## WEST SUSSEX COUNTY COUNCIL CONSULTATION

| <b>LOCATION:</b>           | Land at Woodgate Nurseries<br>Lidsey Road Woodgate                                                                                                                                                                                                   |
| <b>SUBJECT:</b>            | AL/67/26/DOC<br>Approval of details reserved by condition under AL/89/24/OUT relating to Condition 32- Construction Management Plan and Condition 33- Construction Traffic Management Plan.<br><br>Revised CMP in response to WSSC Highways Comments |

SHEET NUMBER 4 OF 4

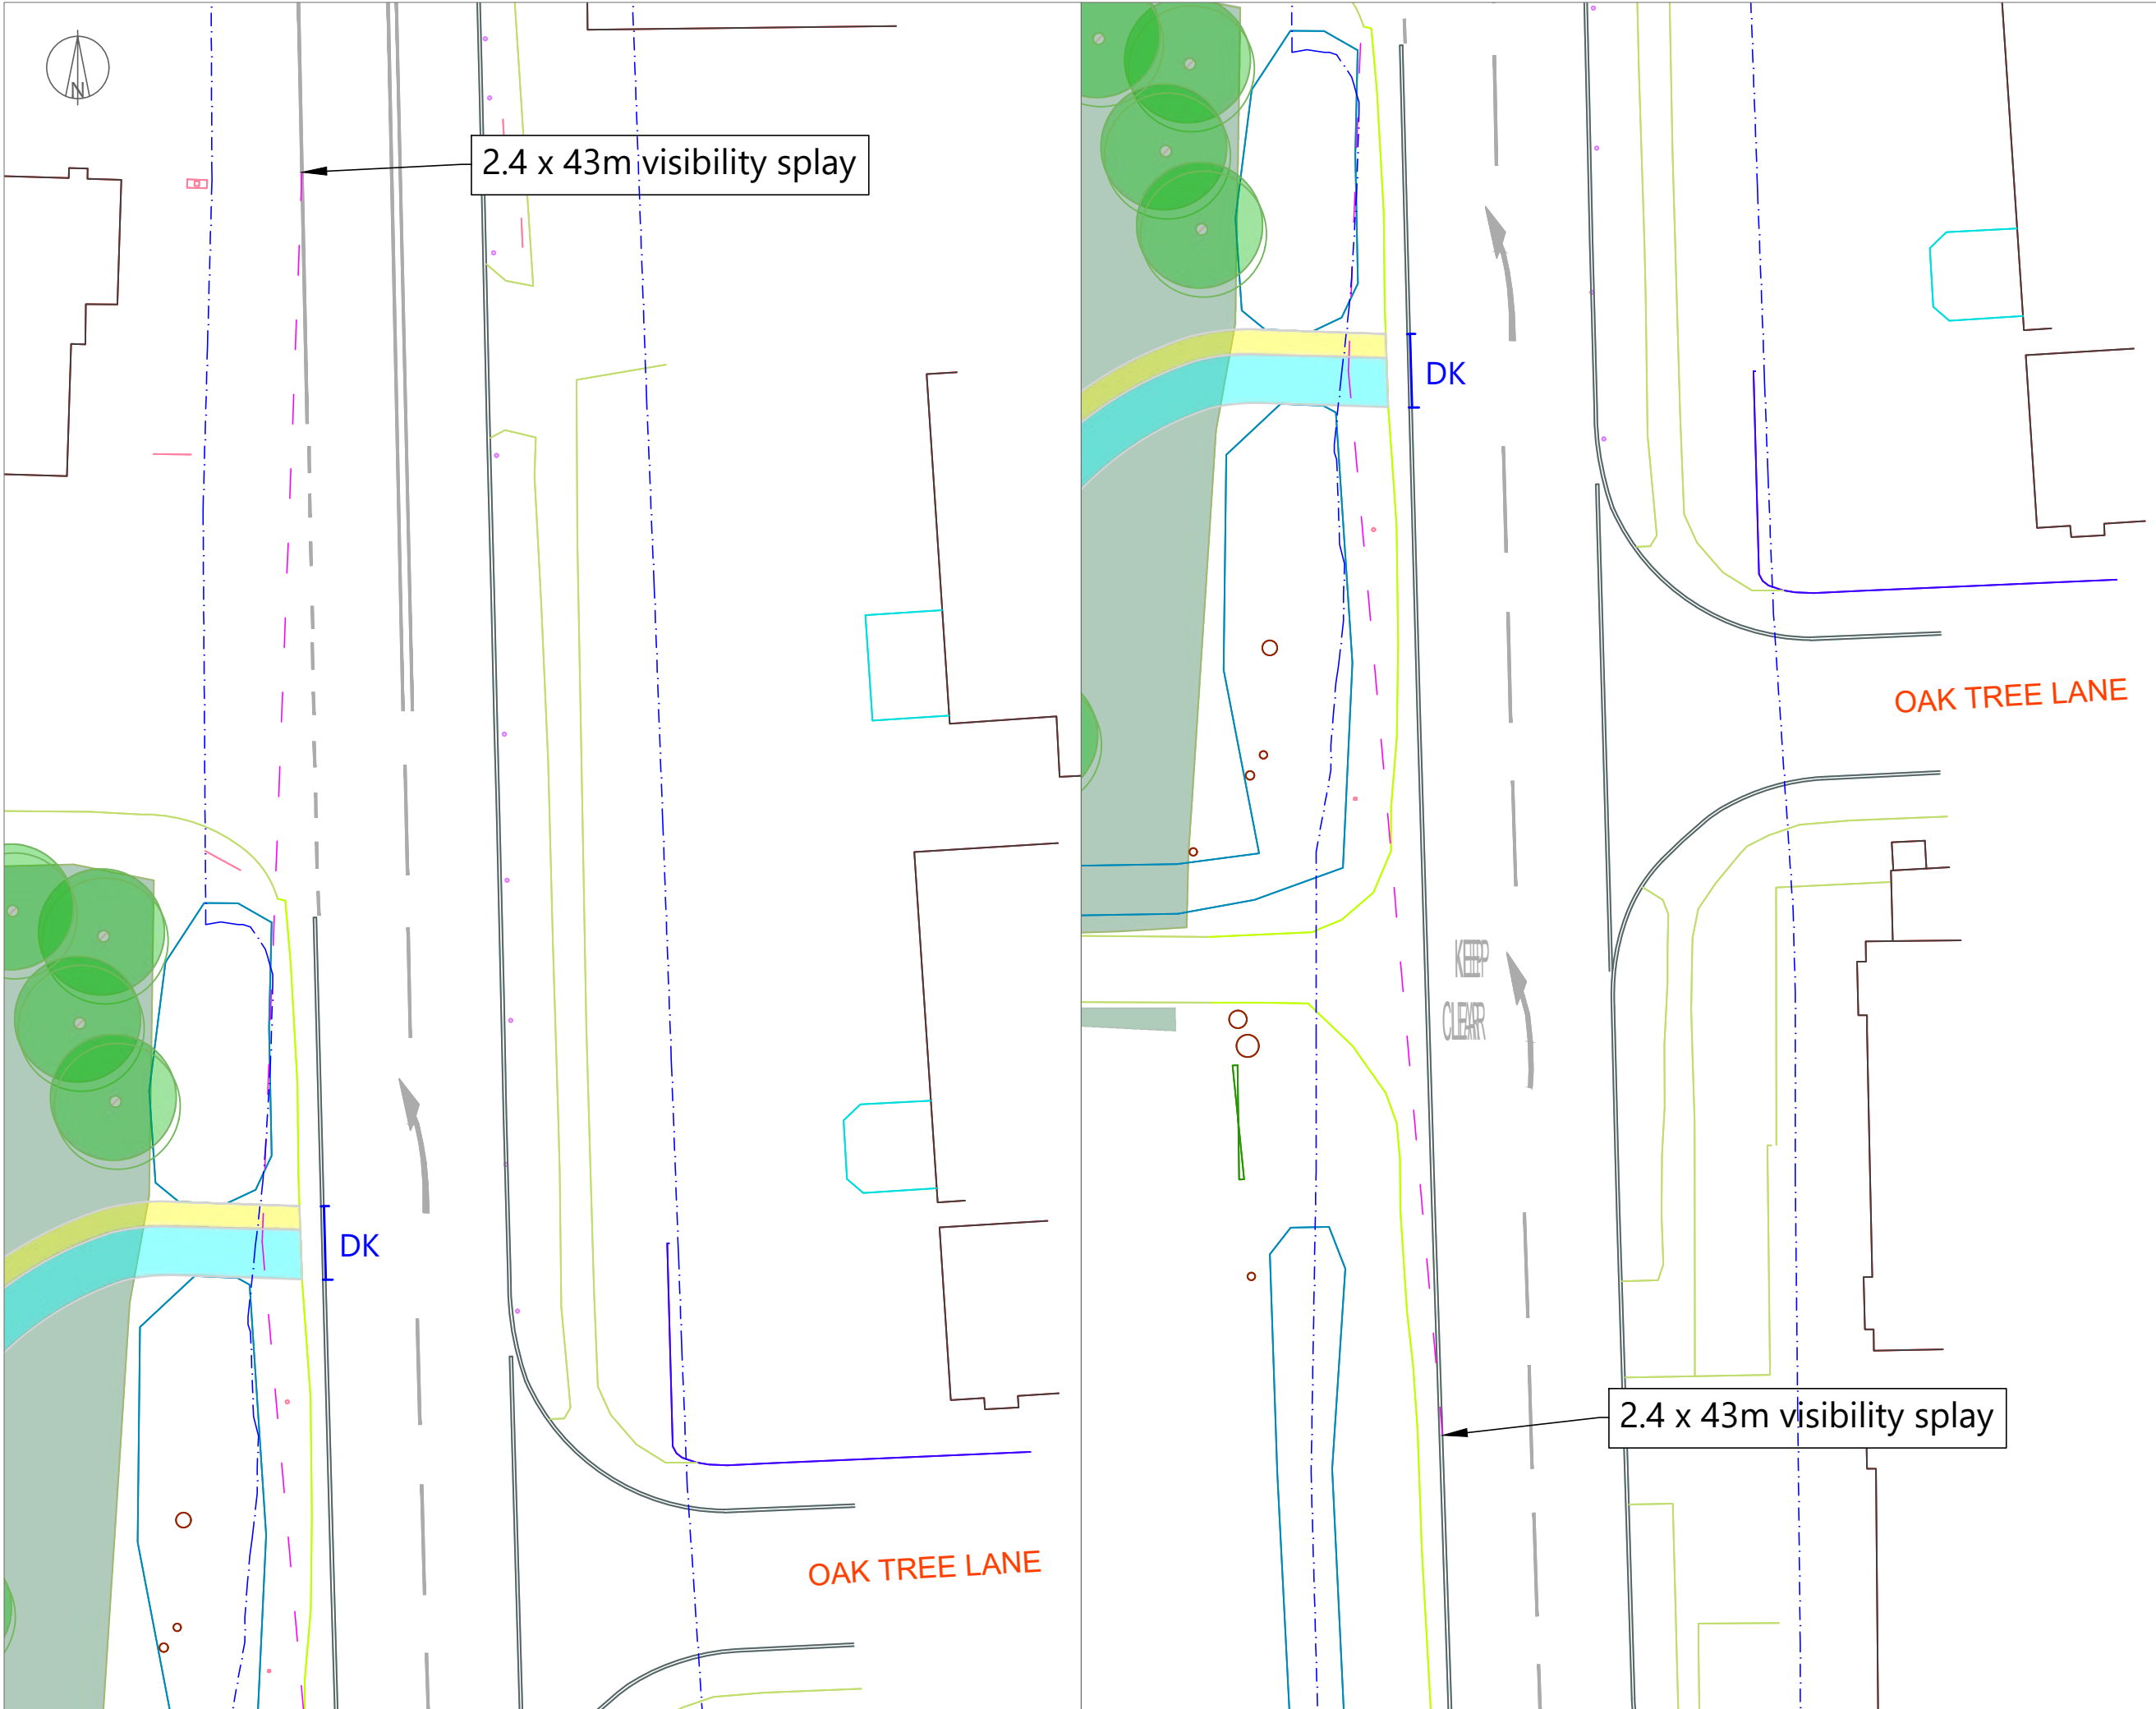
**3.** Visibility splays (including pedestrian visibility splays) must be provided at the exit point onto Lidsey Road for the sales office, and shown as such on a plan to be appended to the final CMS.

*This information is now shown on 'Sheet Number 4 of 4' found as part of Appendix 'E' in the latest version of the CMS.*
